PROPOSED RESIDENTIAL DEVELOPMENT AT STANDEN ESTATE, CLITHEROE

APPLICATION: 3/2012/0942

**PROPOSAL: APPLICATION FOR THE DEVELOPMENT OF A 50.1HA SITE FOR MIXED
USES AT STANDEN ESTATE, CLITHEROE**

The following comments relate to the Transport Assessment (October 2012) prepared by Savell Bird & Axon (SBA) on behalf of the Trustees of Standen Estate (TSE), and the associated additional information that has been submitted during the assessment period by SBA to Lancashire County Council (LCC) as Local Highway Authority (LHA).

The Illustrative Masterplan

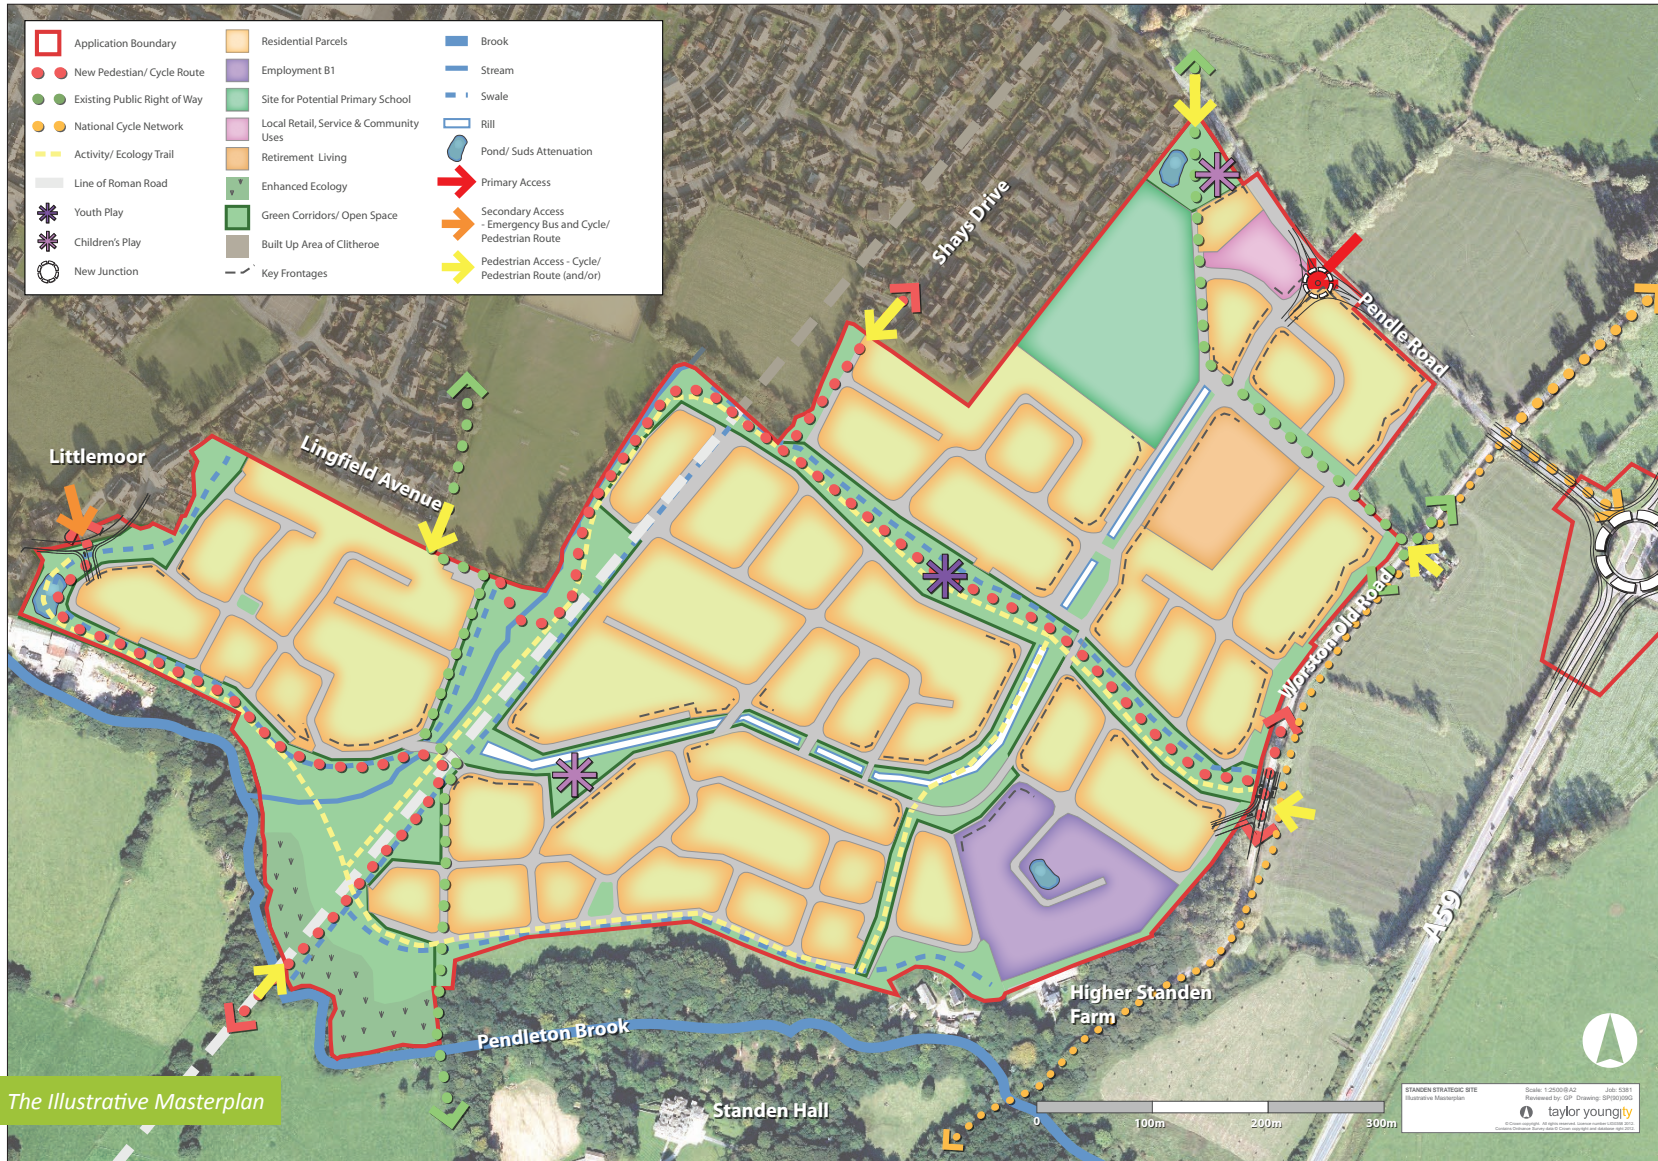
The TA appendices include a proposed Masterplan and parameters plan. This indicates pedestrians and cyclist access from the site to a number of locations;

Further consultation with LCC must be made to review the proposed internal cycle and pedestrian routes within the development. These routes must be attractive to end users, with direct routes to the wider highway network, allowing access to shops, employment, education, leisure and recreational facilities. The internal layout of the site must be designed to maximise pedestrian and cycle permeability with a network of footways and cycleways to link the site to the surrounding local highways and existing pedestrian and cycle network. The following cycling and pedestrian provision should be included in the final site layout;

- direct and continuous cycle links to areas such as Barrow, Primrose and Clitheroe.
- a cycle path along the main distributor road through the development linking Littlemoor to Pendle Way,
- footpaths and cycleways along key routes should be lit where appropriate and agreed, such as to the primary school and district centre, and Lingfield Avenue

Parameters Plan

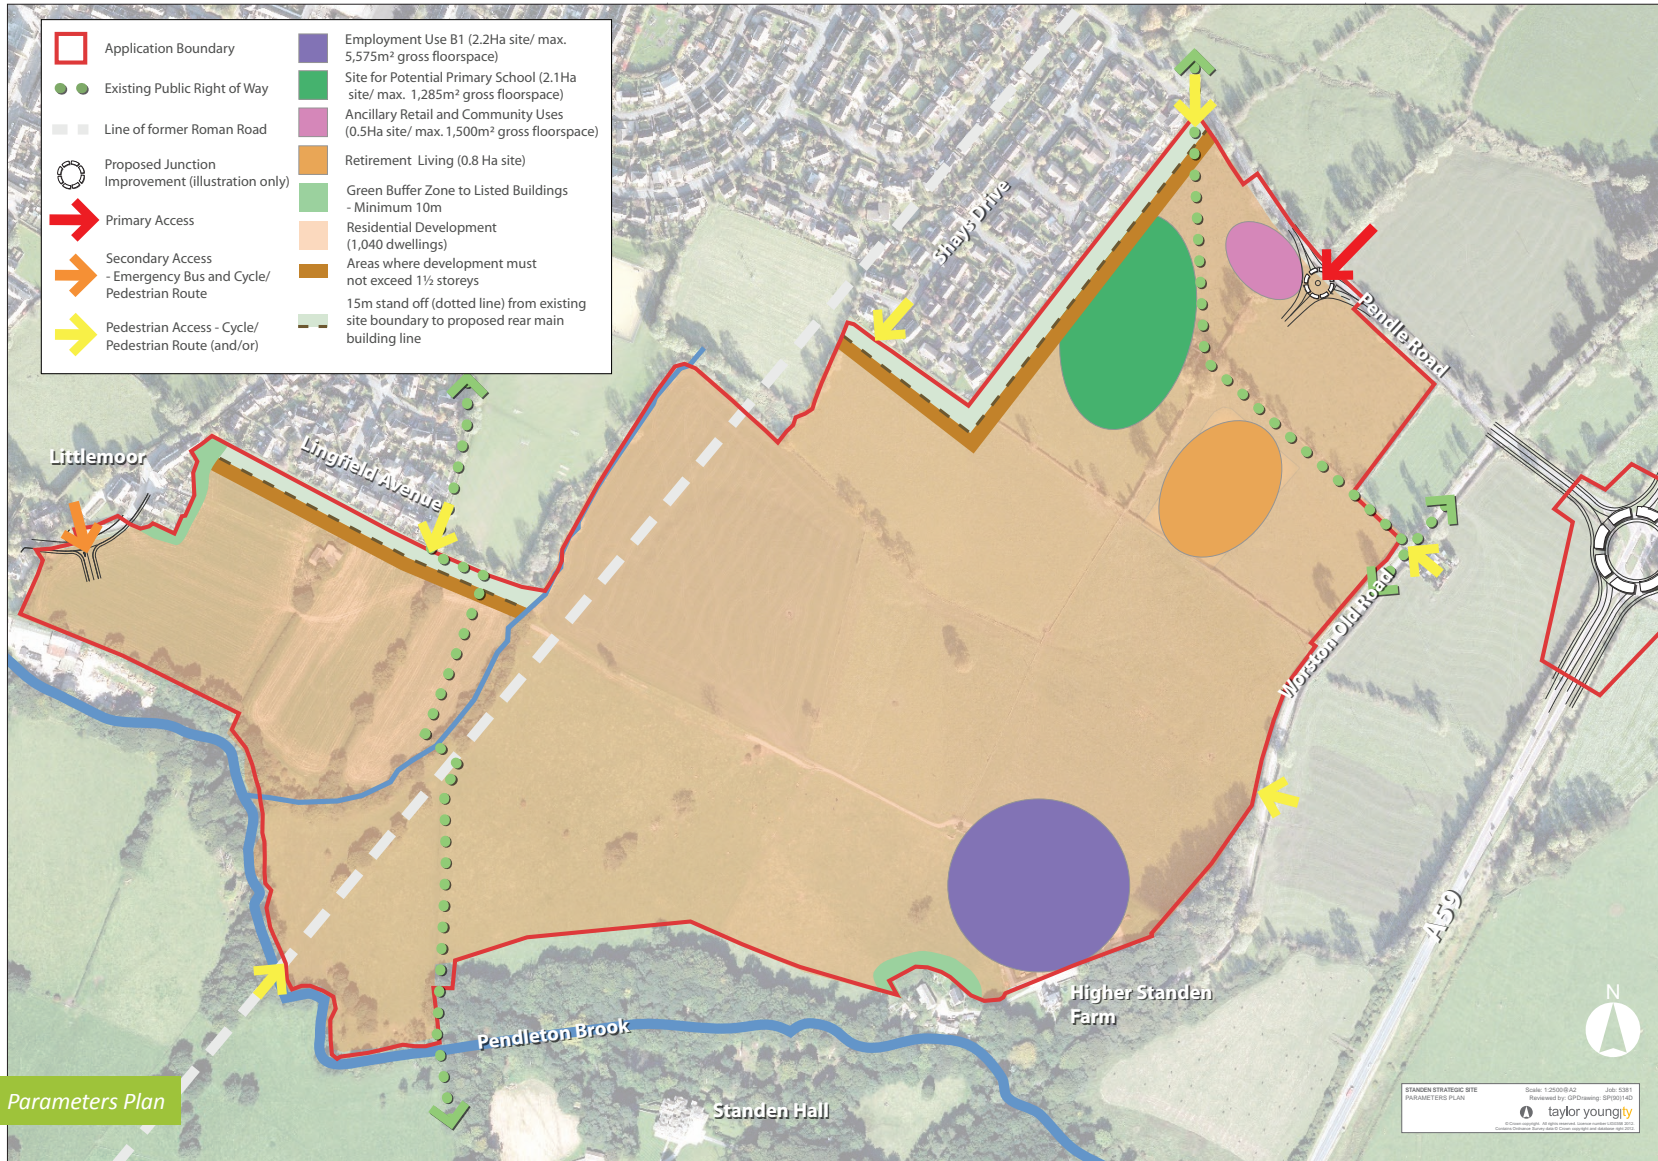
The developer has indicated that a single primary access onto Pendle Road into the development would be a roundabout junction. Additionally, the developer has indicated that there would be an access designated for public transport, emergency vehicles, pedestrians and cyclist use only onto Littlemoor.

LCC has serious concerns with this access strategy. The issue regarding the provision of a secondary access for all modes into this strategic site as requested by LCC has not been resolved and remains outstanding. Access to the site from two highway corridors would offer better dispersion of traffic onto the highway network, allowing greater connectivity of the proposed development with the existing urban area, and allowing a more direct access into the site from areas such as Barrow and Primrose to the new attractions such as the employment area, school and shops, as well as providing improved access (to that proposed) for public transport onto the corridor without constraint. LCC has requested that accesses are provided from the proposed development to the routes of C553 Pendle Road and A671 Whalley Road to the east and west respectively in line with the area of development. This strategy would reduce impact including distance travelled for some car related development trips as access is provided via an alternative corridor which, for some, will be more direct. It is noted

that the illustrative masterplan would include a drive distance of approximately 1.6km from the western side of the site to the Pendle Road access/egress.

The provision of only one access to a development site of this size remains a serious concern to LCC.
